One Carrington SSD

Attachment A - Response to RtS Submissions

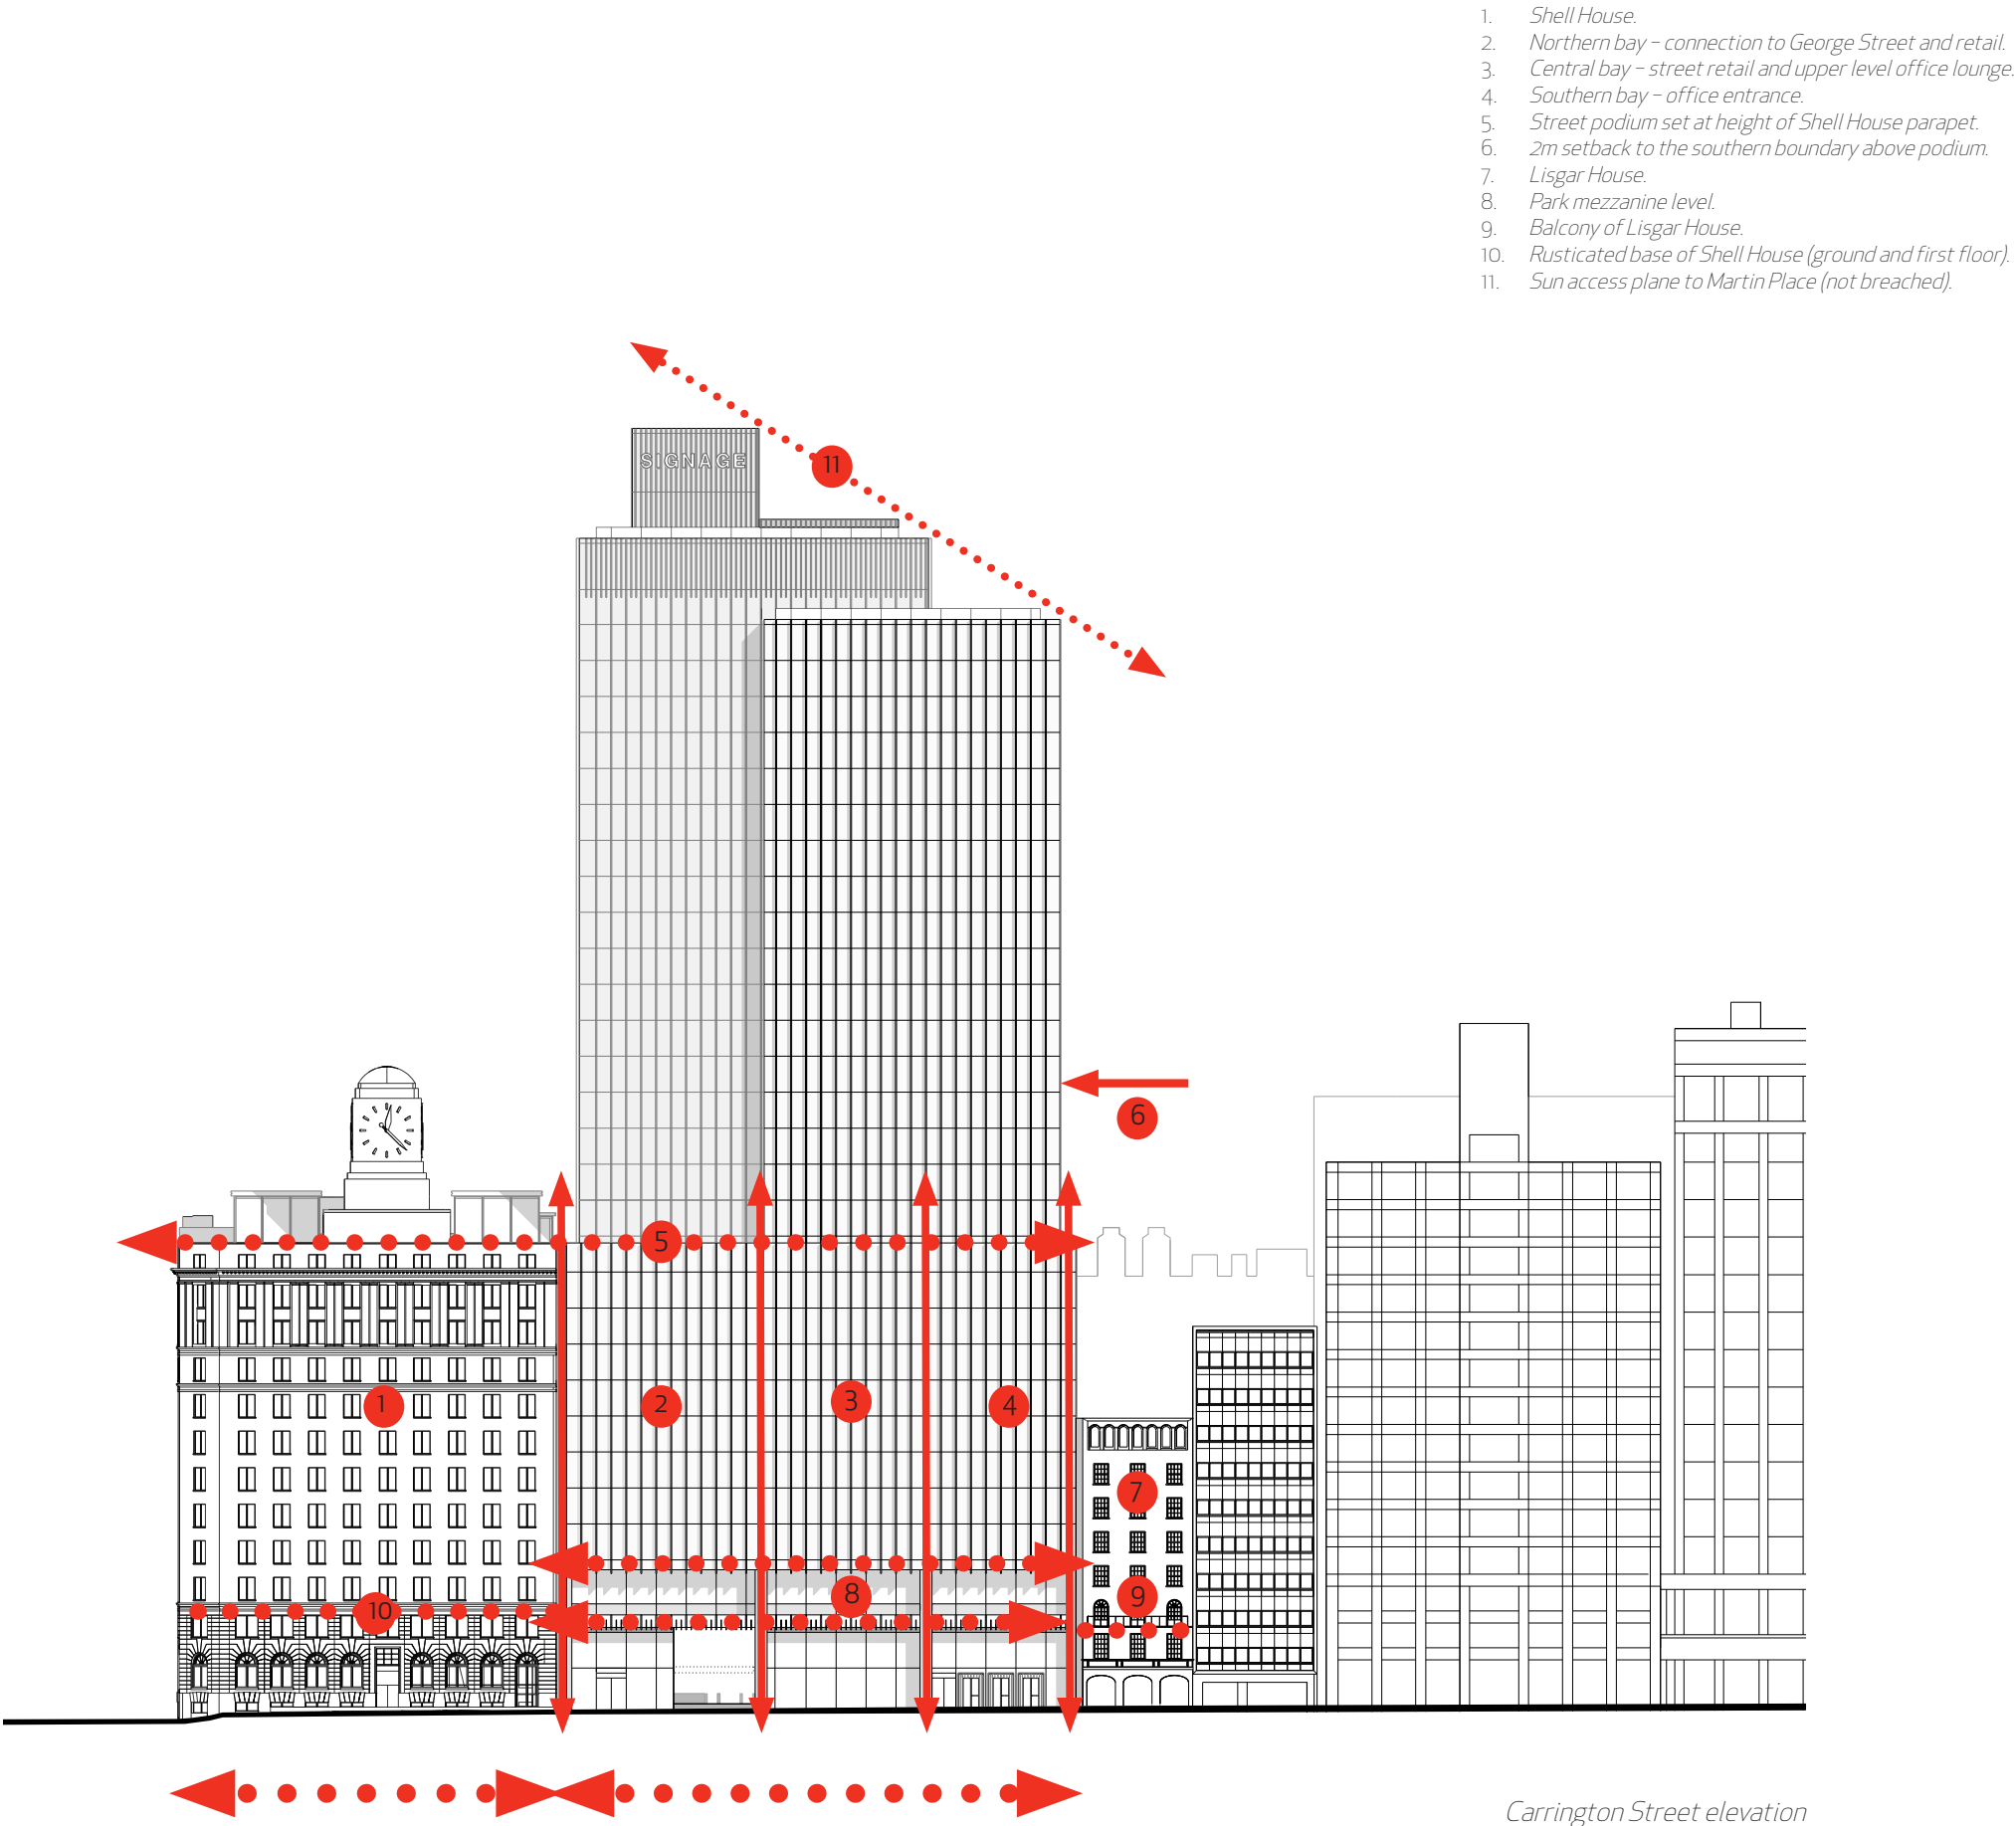
Comment	Response
City of Sydney	
1. Proposed three-bay, 9.1m high, awnings along George Street do not relate well to the adjoining buildings or predominant streetscape character and are likely to be ineffectual in protecting pedestrians from wind and rain. The City has had considerable experience with high level awnings that do not provide adequate weather protection and created the awning controls with the Sydney Development Control Plan 2012 accordingly. Lowering the height of the awnings is considered essential. The City contends that the Wynyard Station entry does not require any particular announcement via higher awnings and lowering the height will not have an adverse impact on the view from the concourse levels to George Street. The Applicant has suggested that the awning design be resolved as part of the detailed design phase in consultation with the City via a condition of consent. Any such condition must specify that the awning design is subject to endorsement by the Director City Planning, Development and Transport. In the absence of such a condition the City objects to the proposed awning element of the current SSD application; and	The City of Sydney's comment is noted.

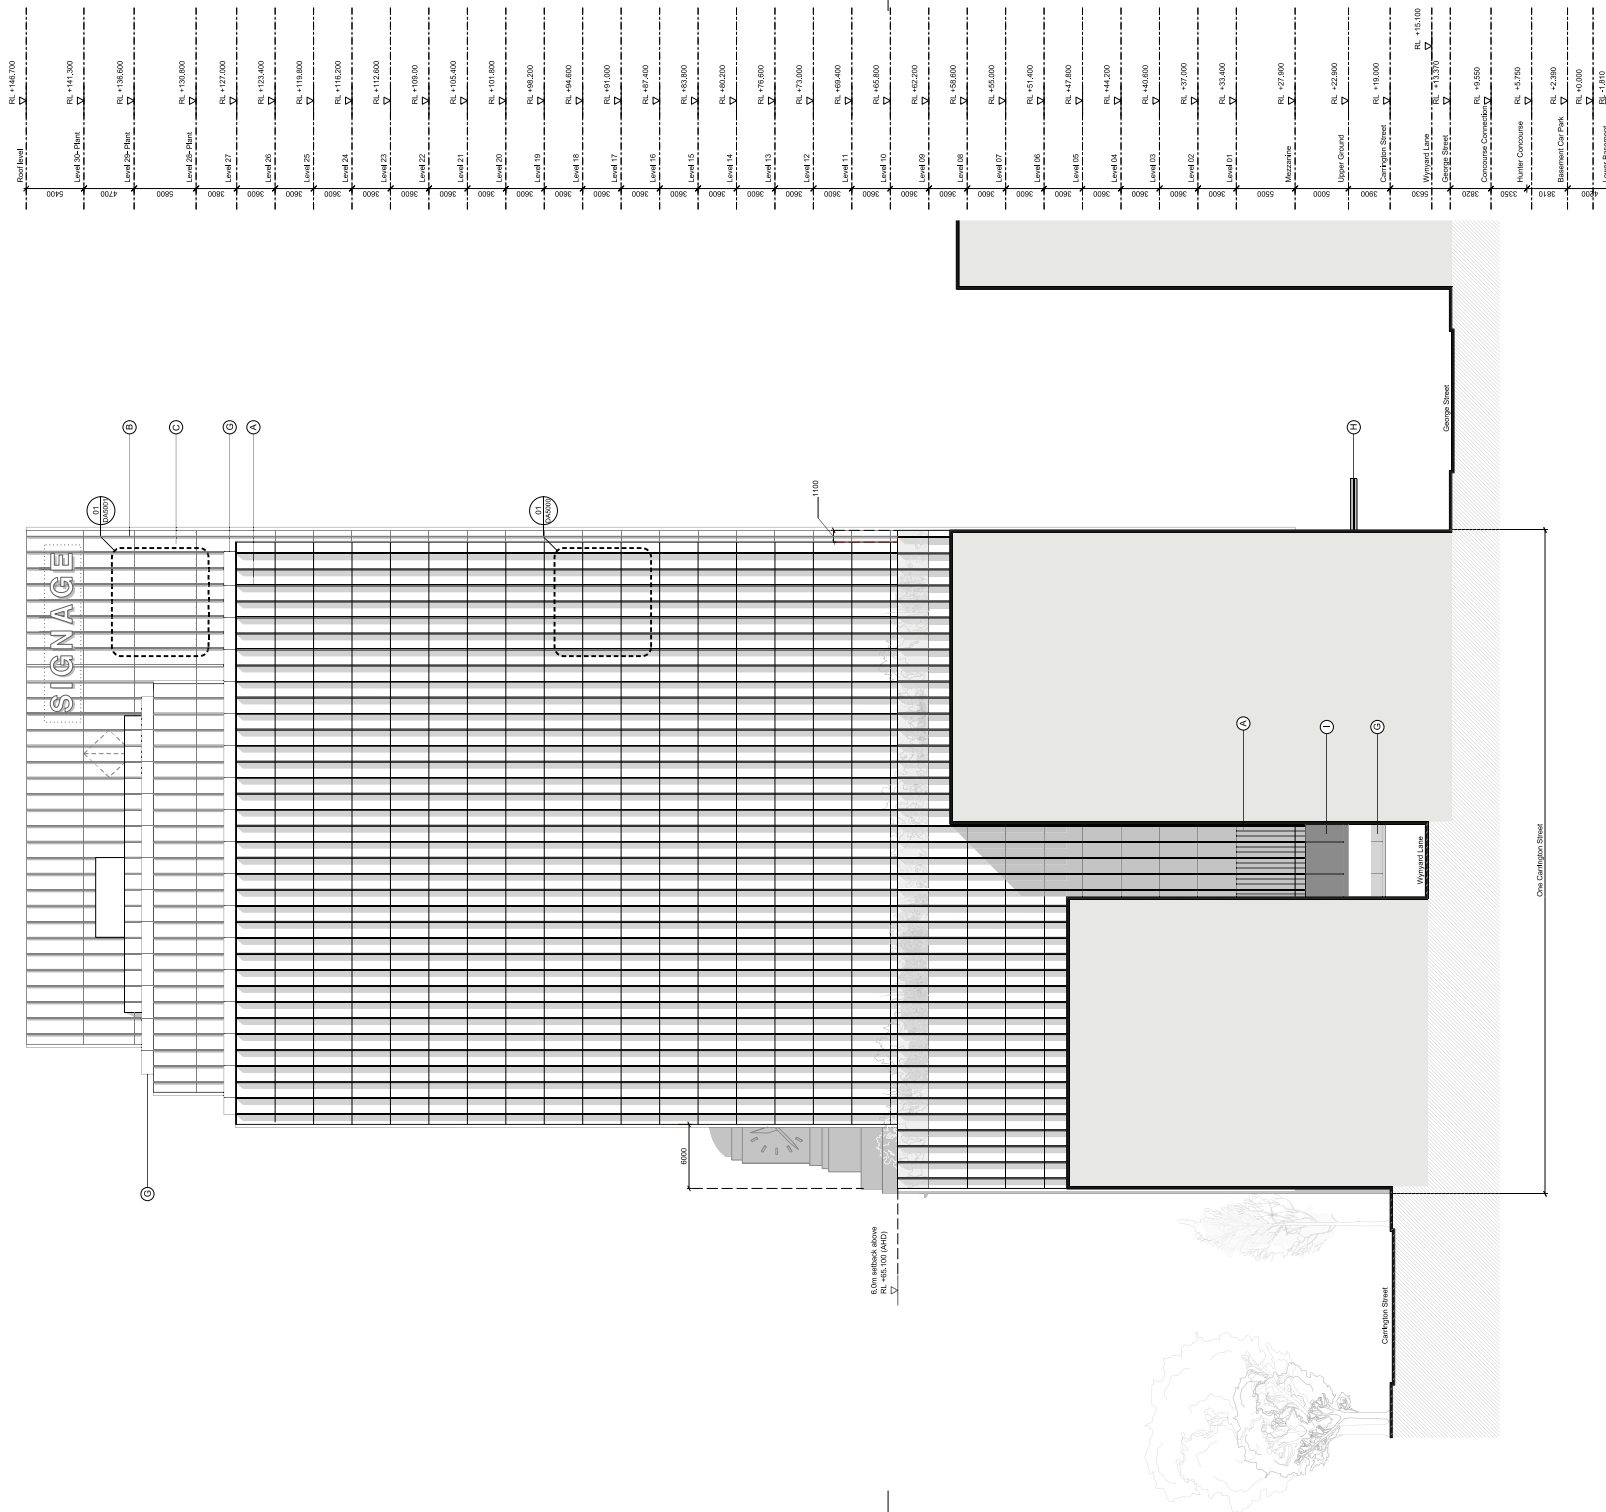
2. Proposed facade treatment along Carrington Street and George Street lacks the masonry and comparatively small window-to-wall elements that dominate the streetscapes in the vicinity and the City's desired future character for the northern end of the CBD. The curtain glazed podium does not relate well to the context and an insufficient response has been provided regarding the project's justification for being vastly different to the dominant character. The City contends that the street wall height of the development should be clad in sandstone with a corresponding reduction in window-to-wall ratio.	Brookfield does not believe any additional assessment is required. The Architectural Response at Attachment E of the Response to Submissions clearly demonstrates that the proposed materiality and design of the podium is appropriate.
Transport for NSW	
Construction Vehicle Access along York and Carrington Streets TfNSW does not support Brookfield's current proposal for unfettered use of Carrington Street for construction vehicles due to the following reasons: ▪ A high level of bus movement is currently occurring on Carrington Street, York Street also currently accommodates significantly more buses than Carrington Street during peak periods.	Noted.
